**EPC STORMWATER REVIEW COMMENTS ARE SHOWN IN ORANGE BOXES WITH BLACK TEXT**

**TITLE PAGE**  
**EROSION AND STORMWATER QUALITY CONTROL PLAN**  
**Aura at Crossroads Electric and Gas Main Installation**

PCD Filing No: CDR-22-013  
 Prepared By: JPH  
 Date: June 2022

CONTROL MEASURE DETAILS
EROSION AND STORMWATER
QUALITY CONTROL PLAN

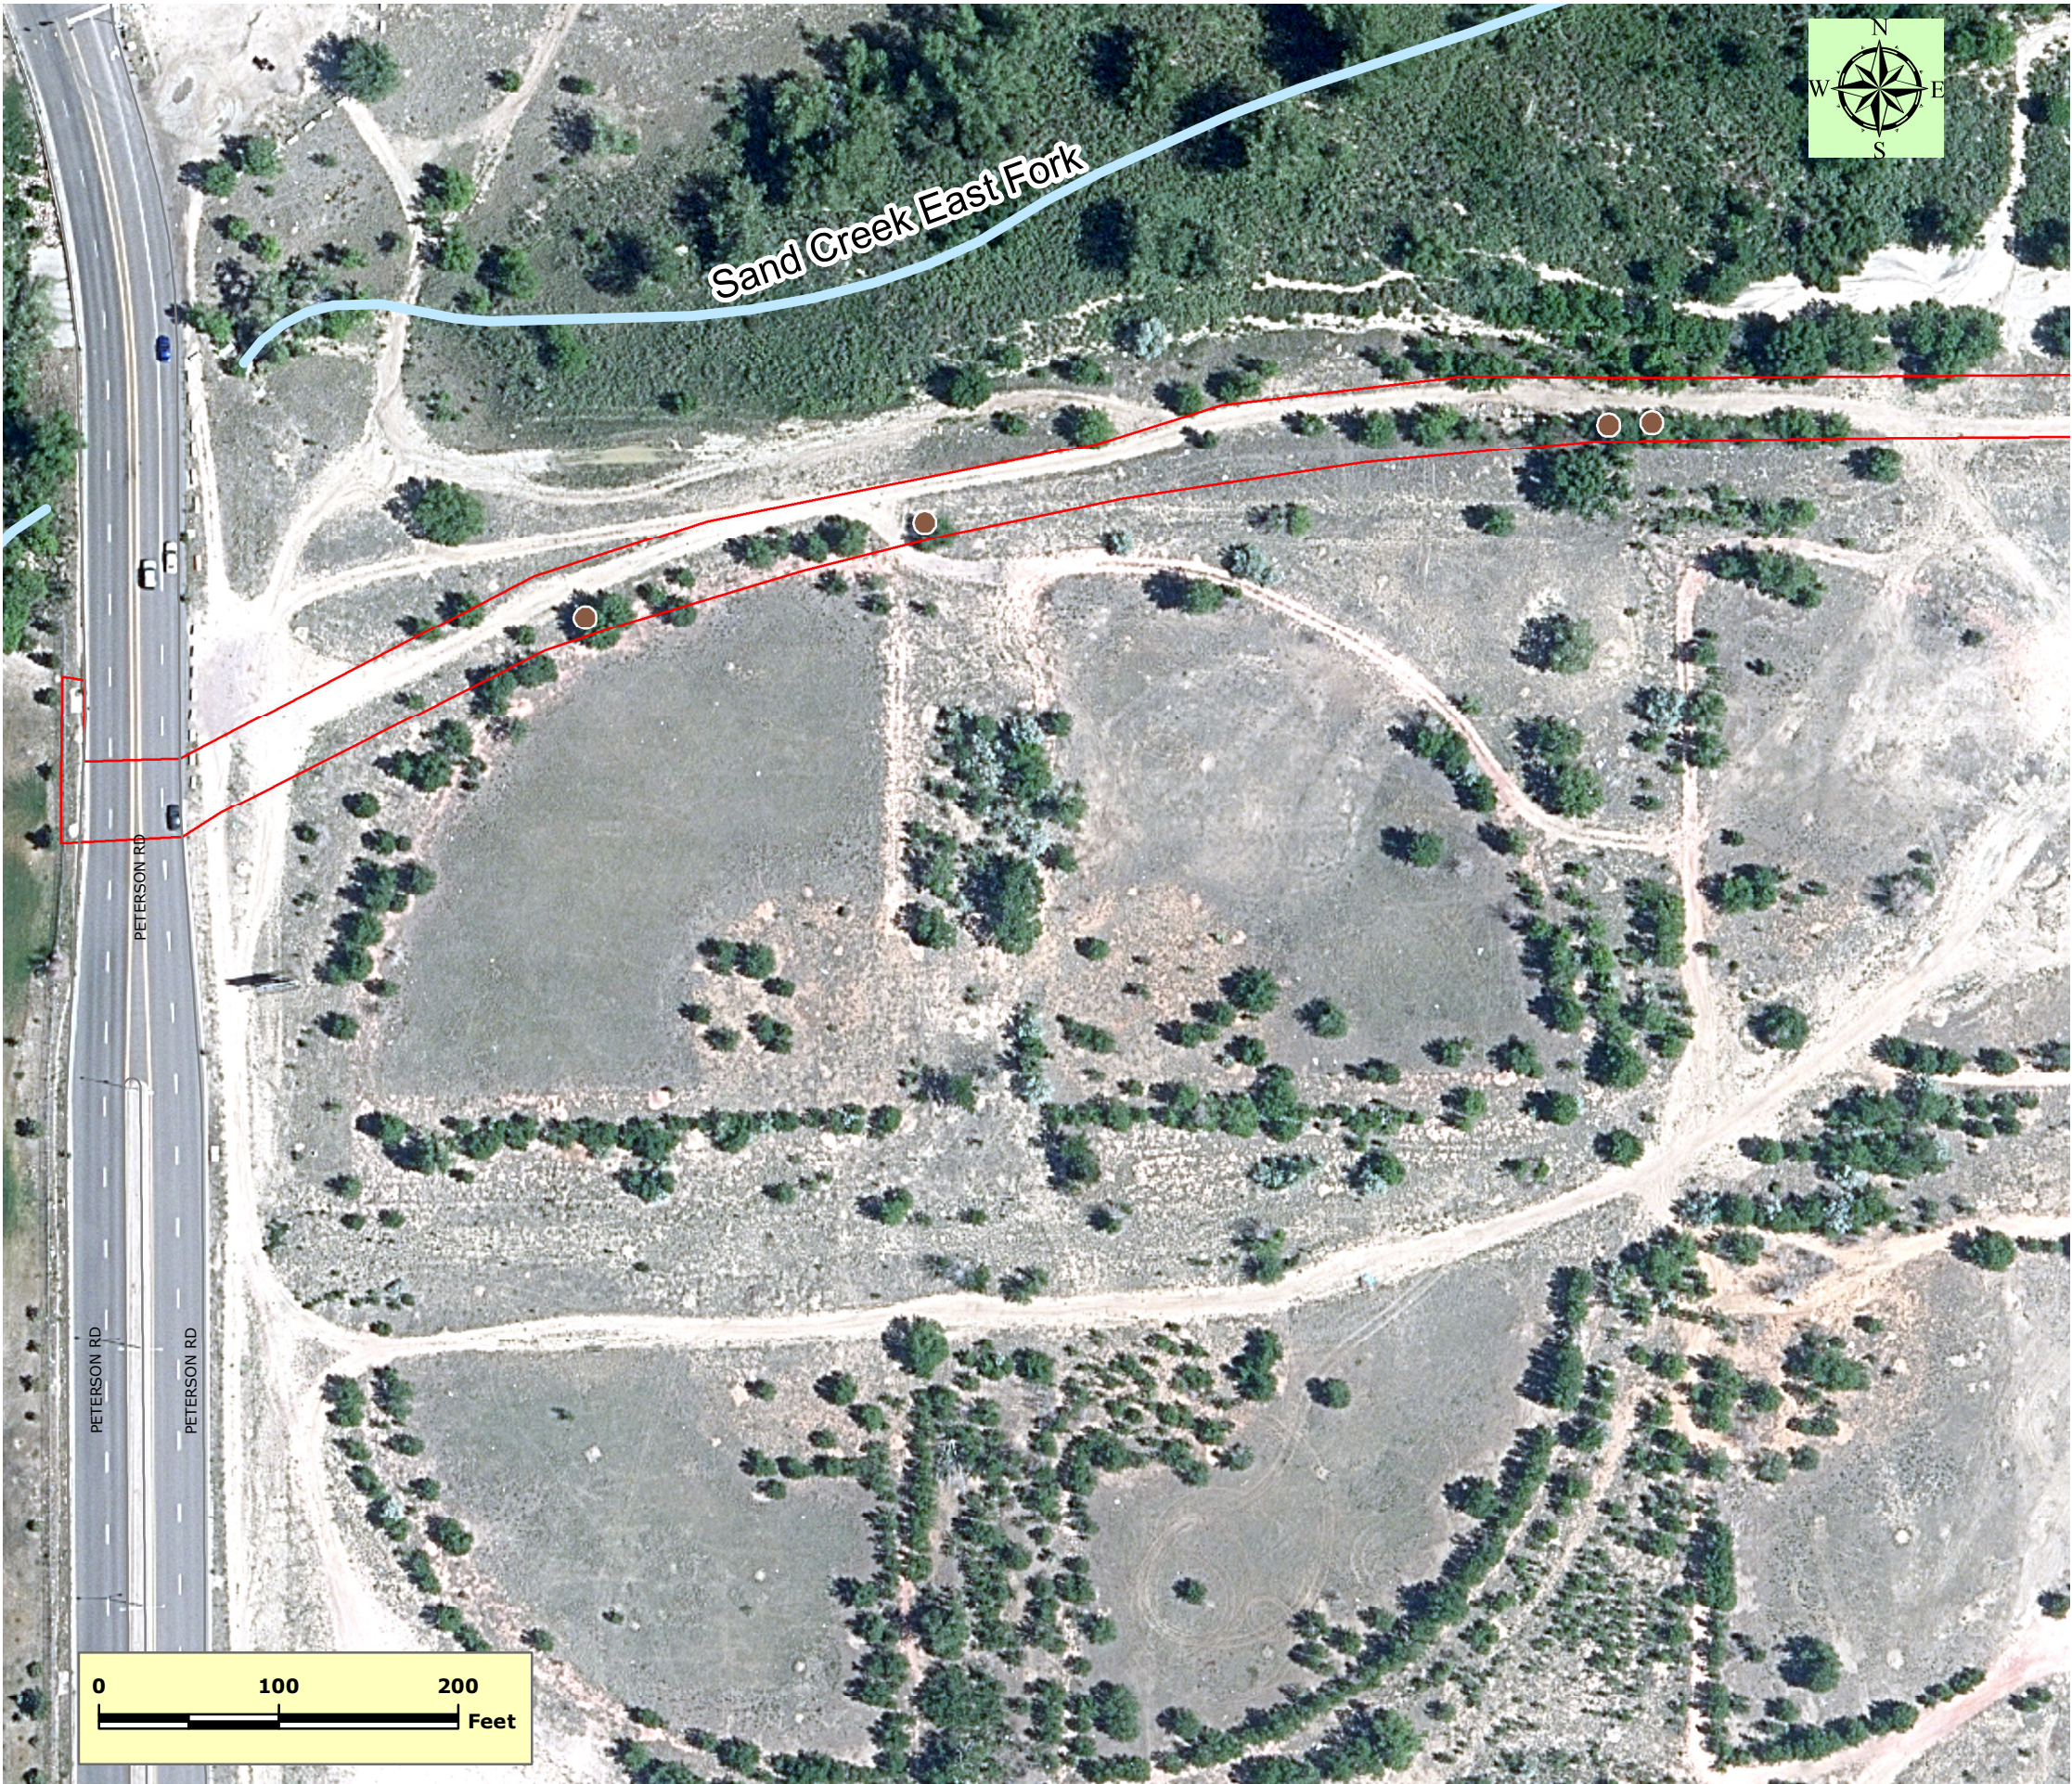
move BMP details to separate sheet so that they are legible when printed. Include inlet protection detail for Peterson Rd and Seeding details.

**Figure
Number
3 WEST**

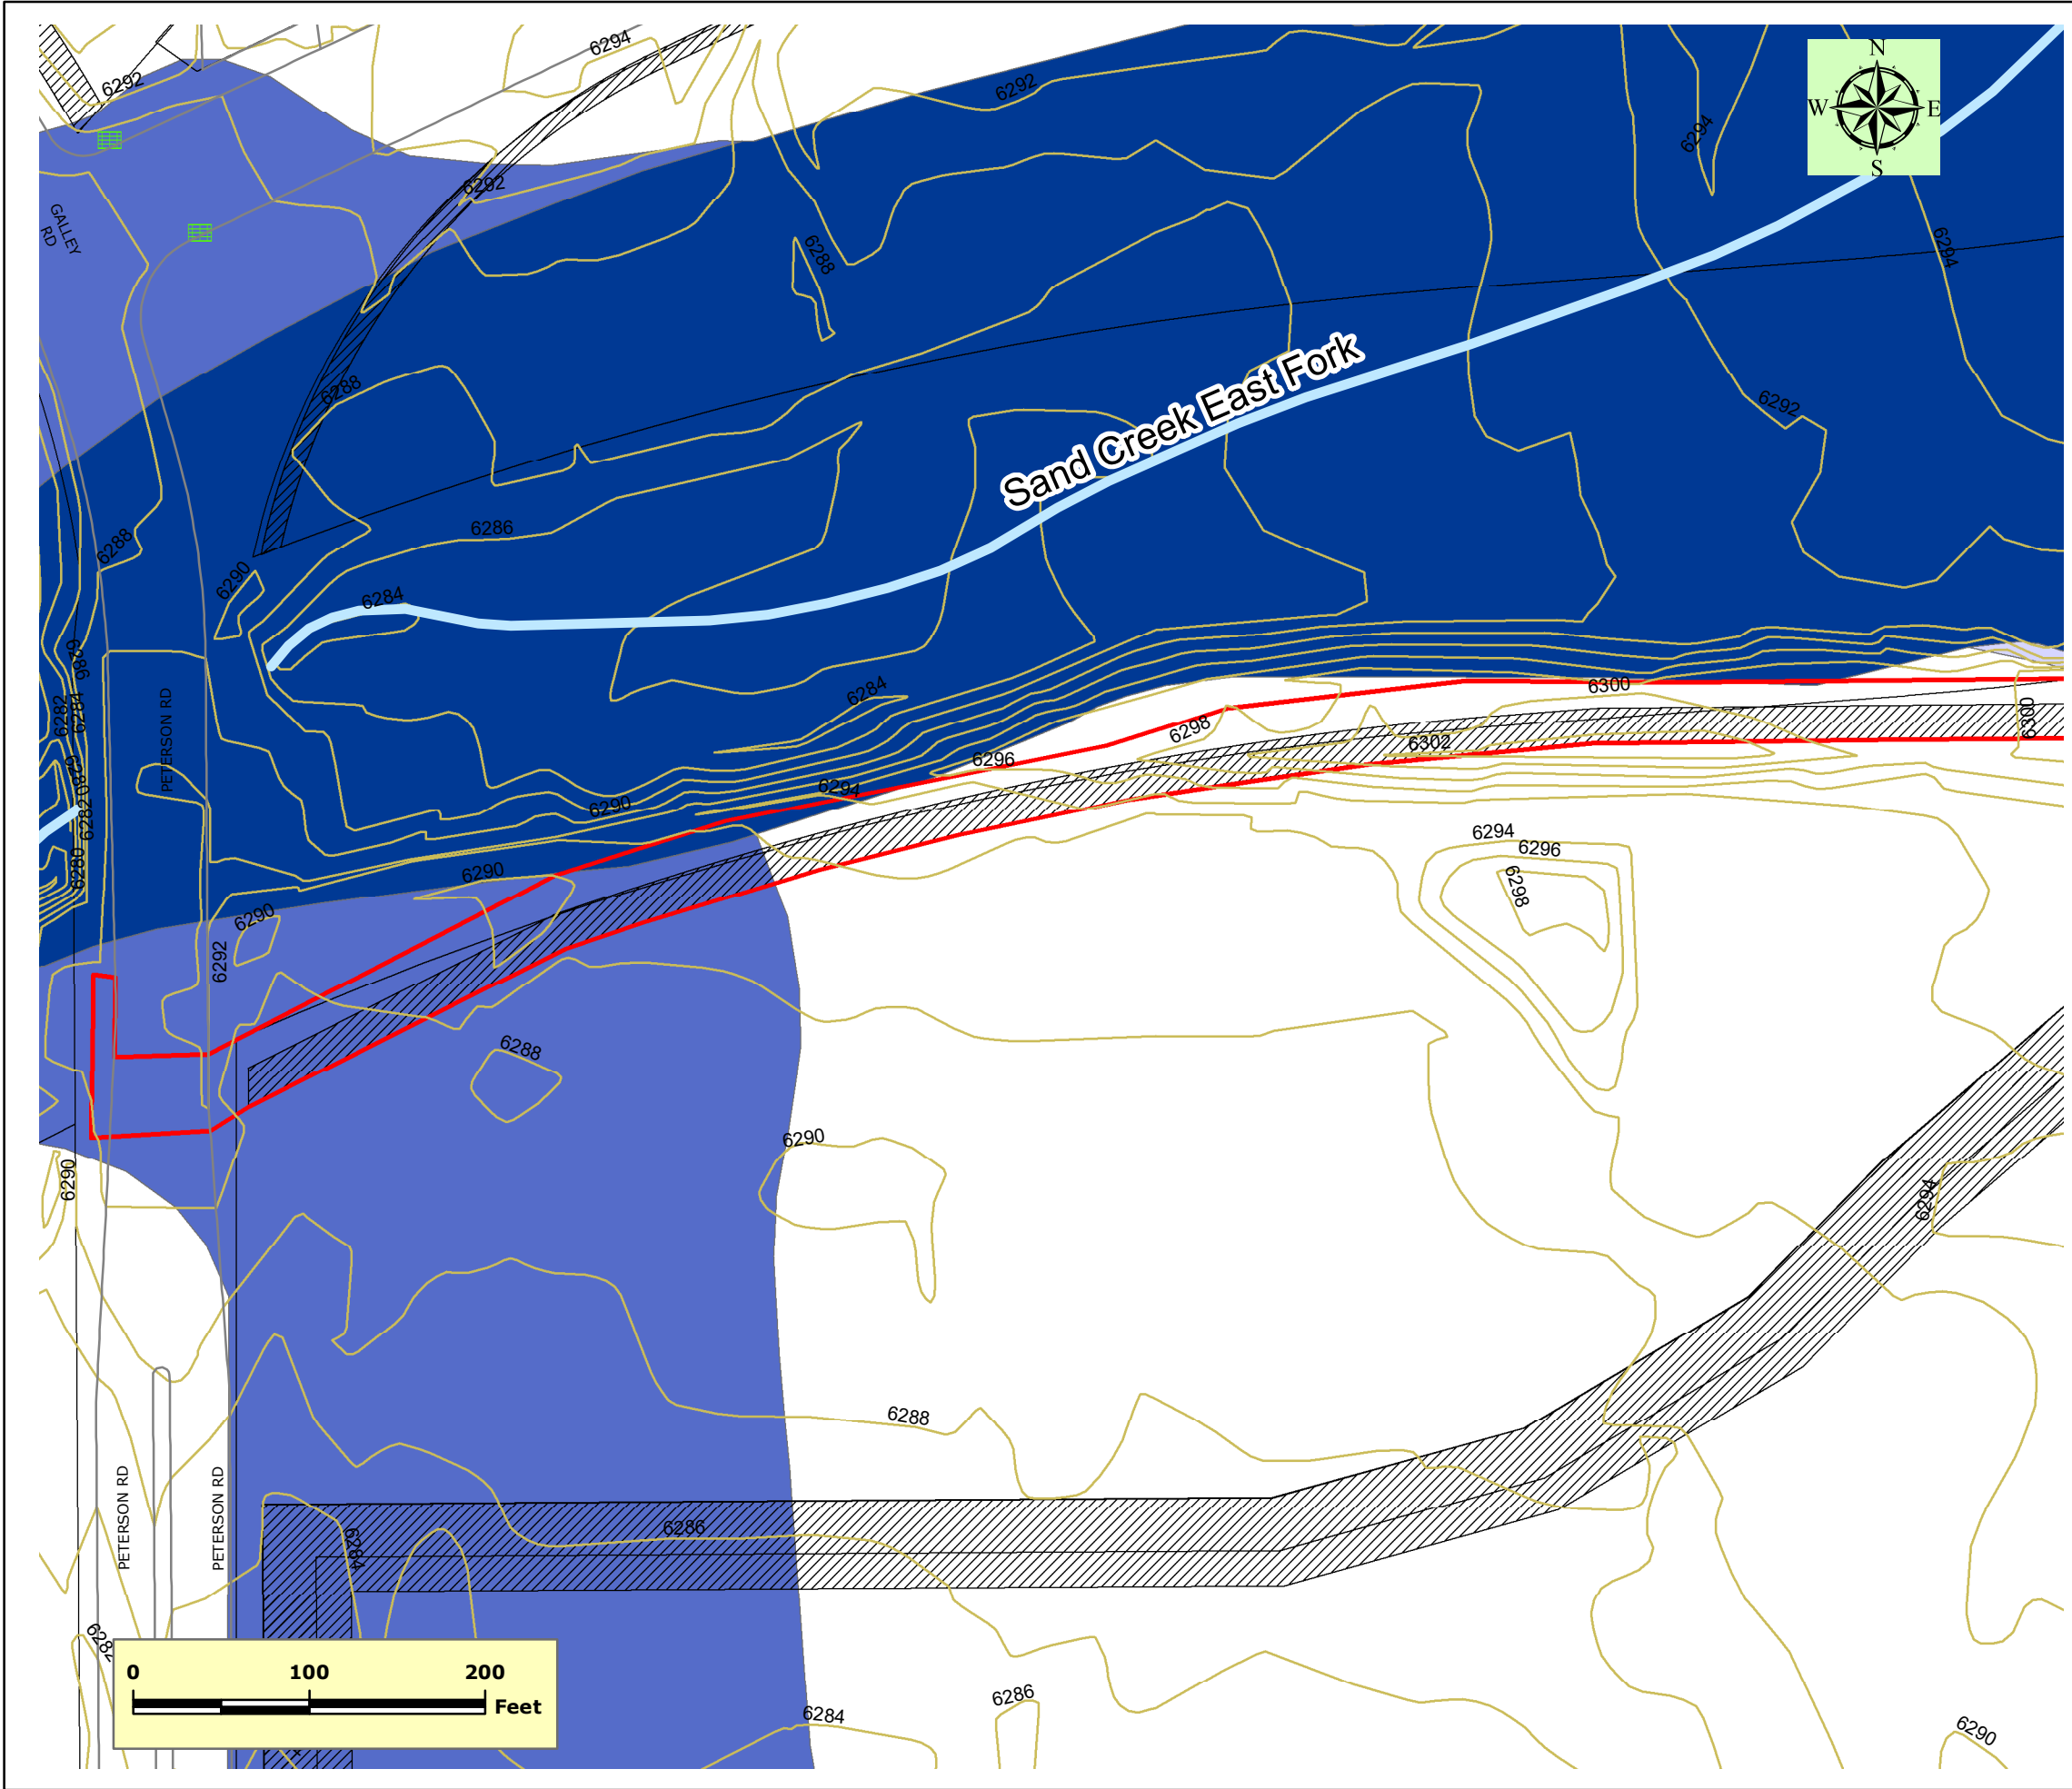
will the road need to be closed during construction or do you plan to bore?  
GEC Checklist Item n.

**Figure
Number
4 WEST**

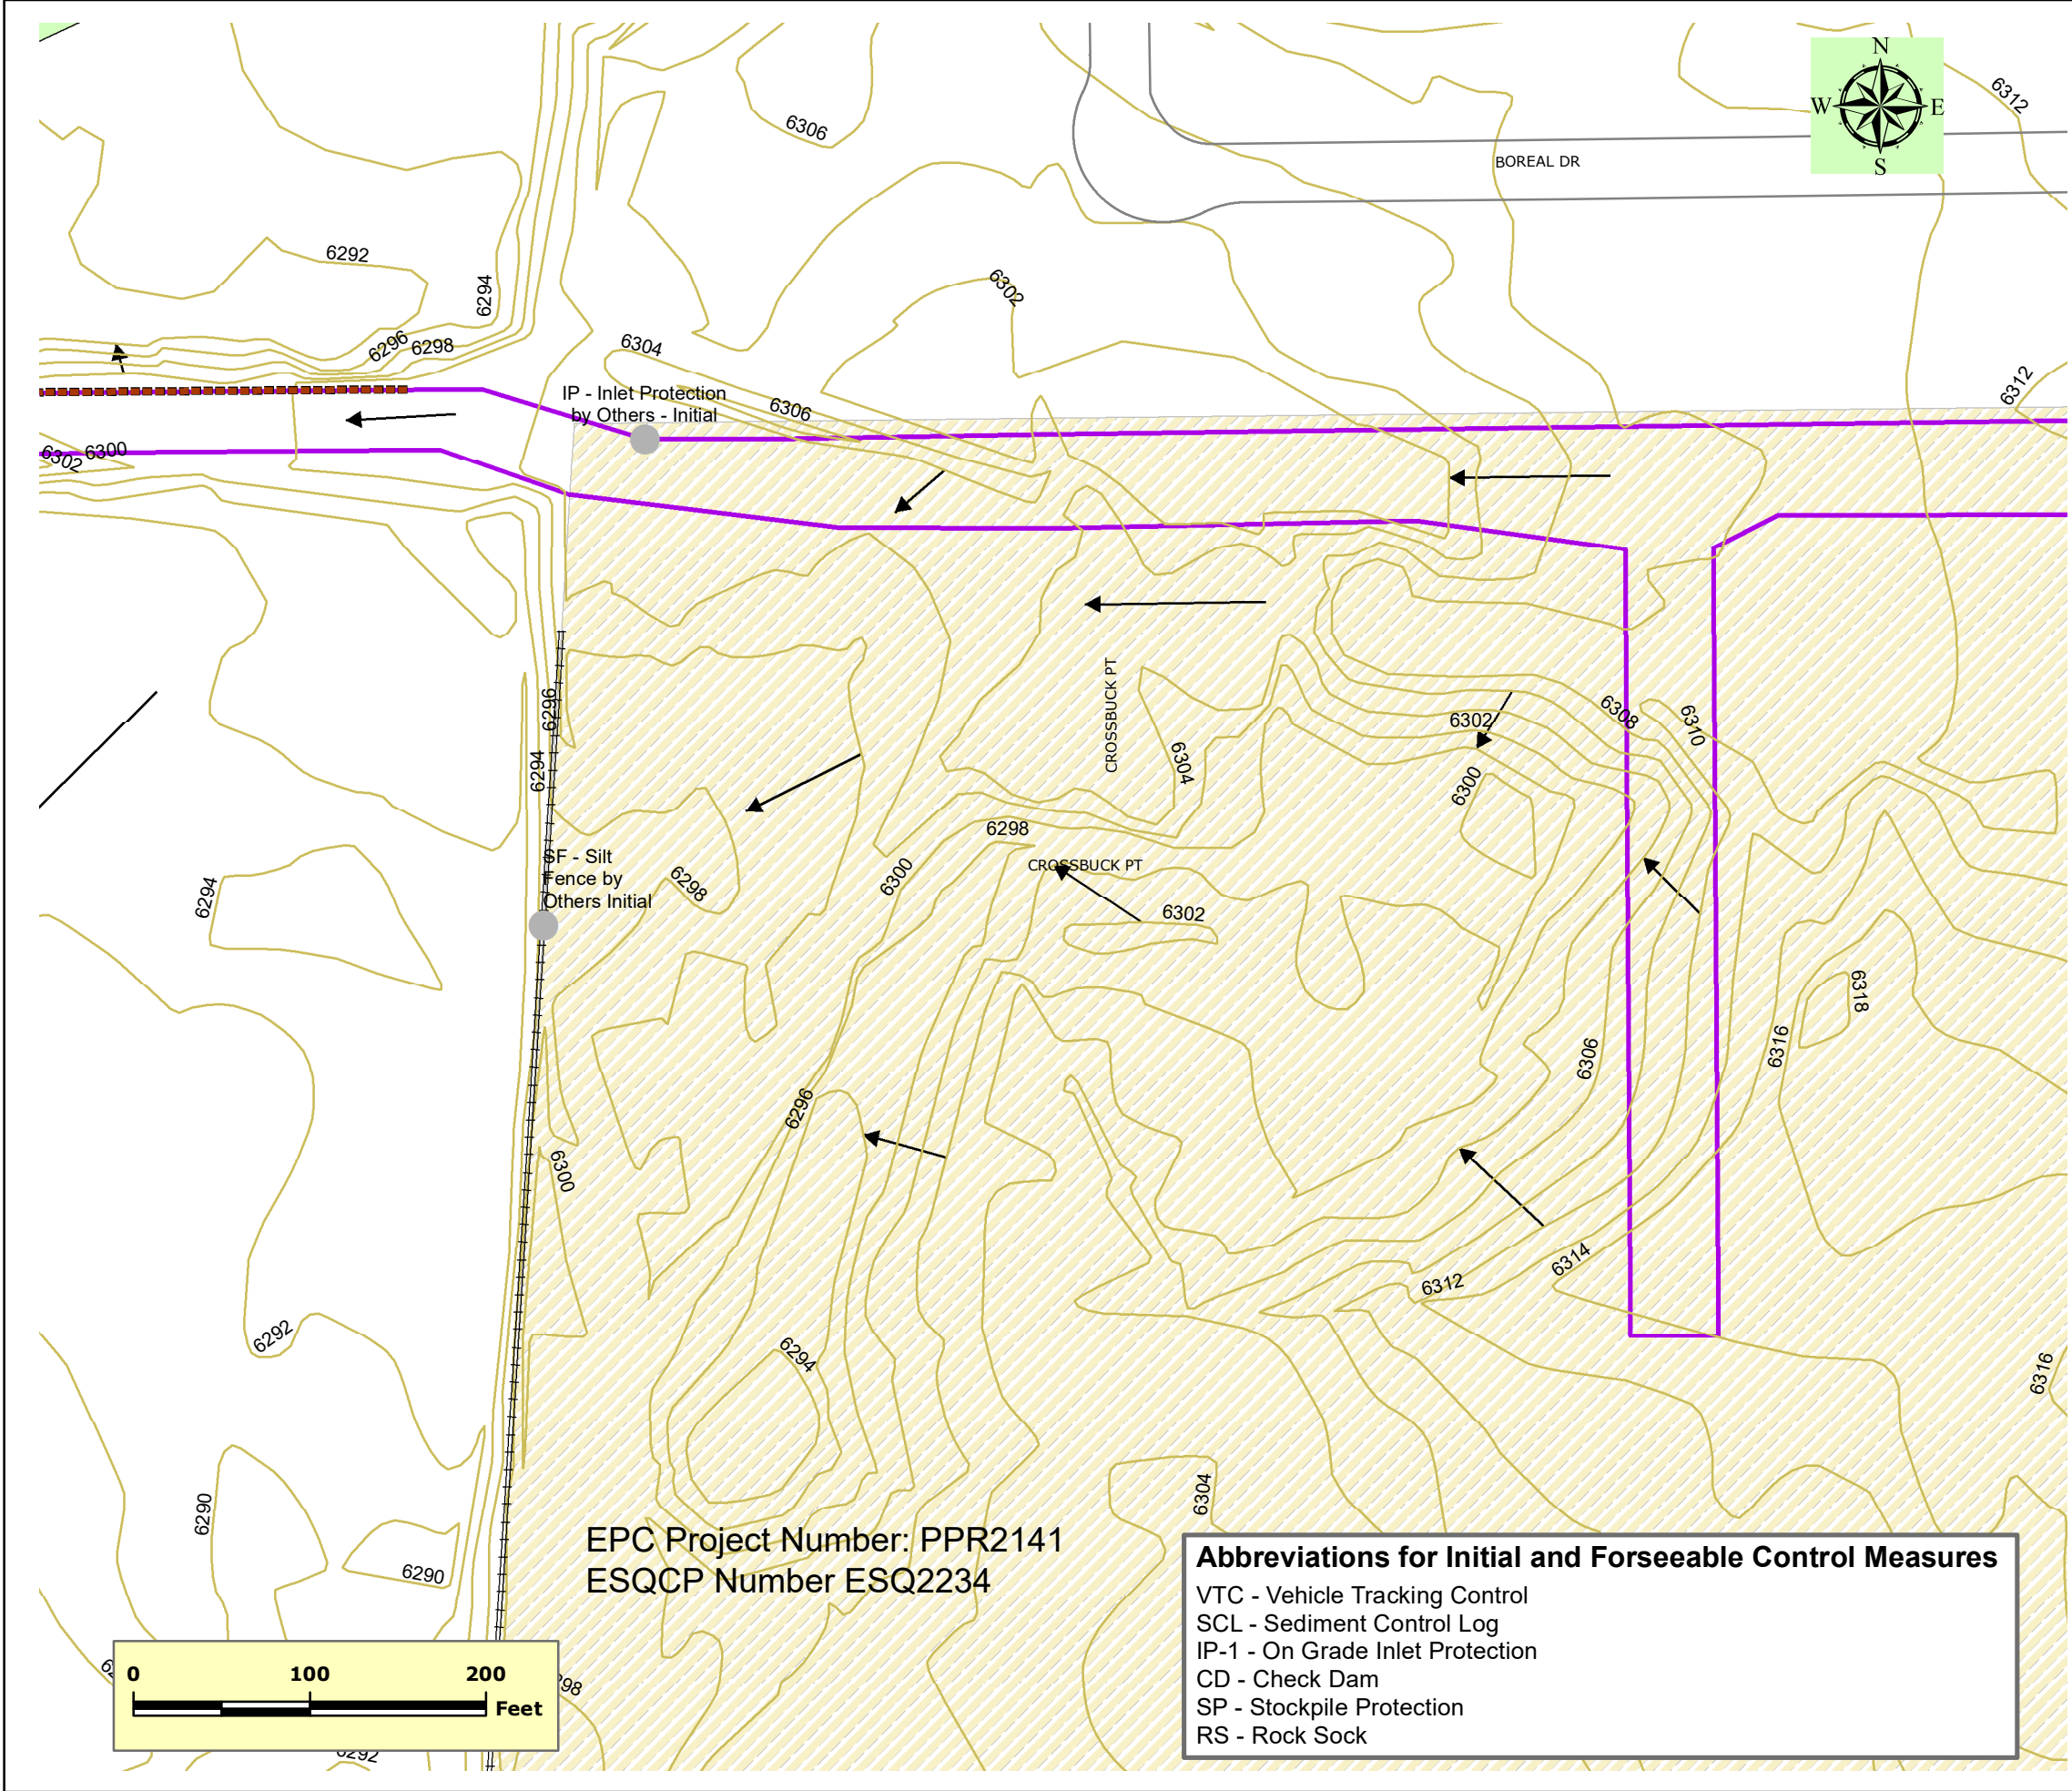
show areas of seeding and mulching
